10 October 2017

Our Ref F10/47  
Contact Alexandra Vandine 95621835

**Re: Bayside Council Response to Modification Eastlakes Shopping Centre (MP 09\_0146 MOD 2)**

DRAWING TITLE
**CONSTRUCTION PLATFORM
VEHICLE TURNING PATH**

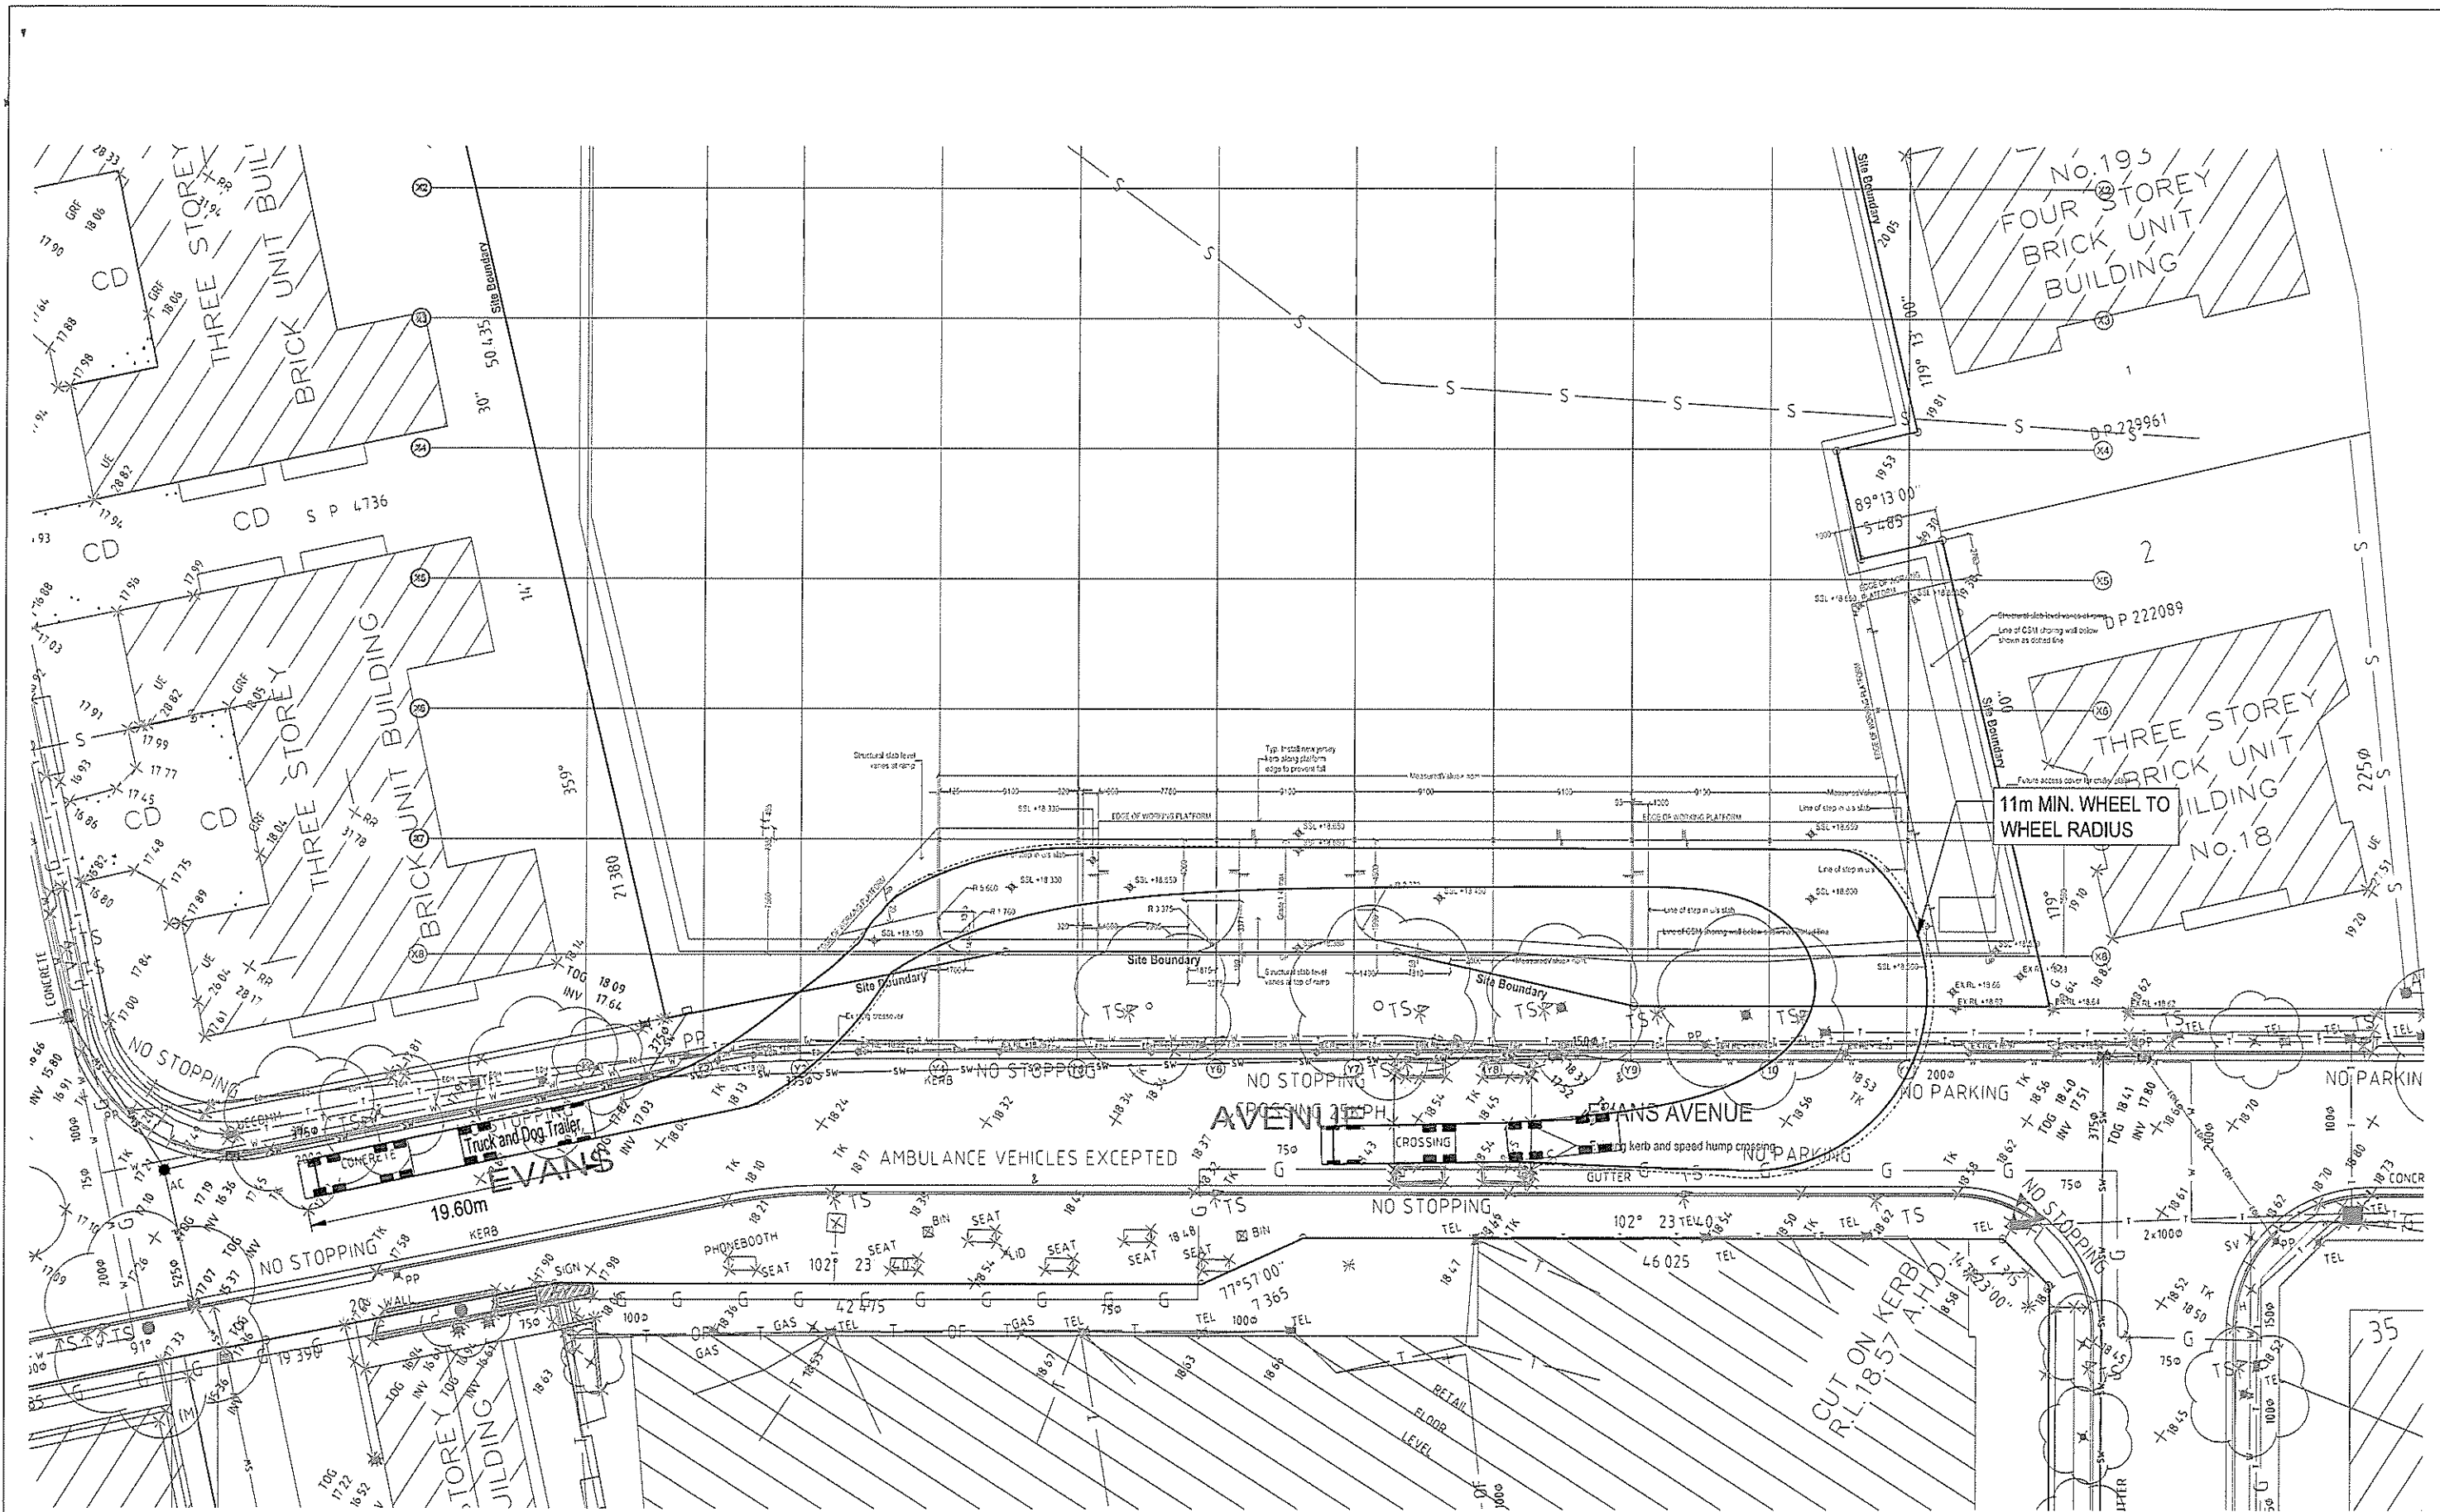
Bayside Council notes that modification request 2 is in relation to “*Modification to Condition B29(e) to allow larger construction vehicles up to 19 m in length to be used during construction*”. This is an increase from the original approved length of construction vehicles of 12.5 metre. Council acknowledges the application proposes a reduction in the number of truck movements required to access the site, from 6,500 truck movements to approximately 2,300 and to reduce the total time taken to complete the excavation. Council also acknowledges that a swept path analysis has been undertaken for ingress and egress at the site, from Evans Avenue, Eastlakes. The swept path analysis demonstrates the feasibility of a 19-metre-long truck and trailer accessing the site.

Bayside Council appreciates the concept of reducing truck movements as part of this development. However, many of the streets around this development are restricted in width and are already at capacity. As such Council also requests that a swept path analysis be provided for the following intersections:

- Gardeners Road and Racecourse Drive, Eastlakes and
- Racecourse Drive and Evans Drive, Eastlakes

to ensure the movement of larger trucks can be facilitated through these intersections. Council is aware that 12 metre buses already face difficulties in moving through these intersections and therefore has significant concerns about the practicality of a 19 metre truck completing such a manoeuvre without causing significant traffic issues and potential infrastructure damage.

In addition Council also requests investigation of existing road pavement adequacy to cater for the largest proposed vehicles and design and reconstruction of the road pavement for the travel route identified above, in accordance with Austroads – Guide to Pavement Technology Part 2: Pavement Structural Design, 2012.
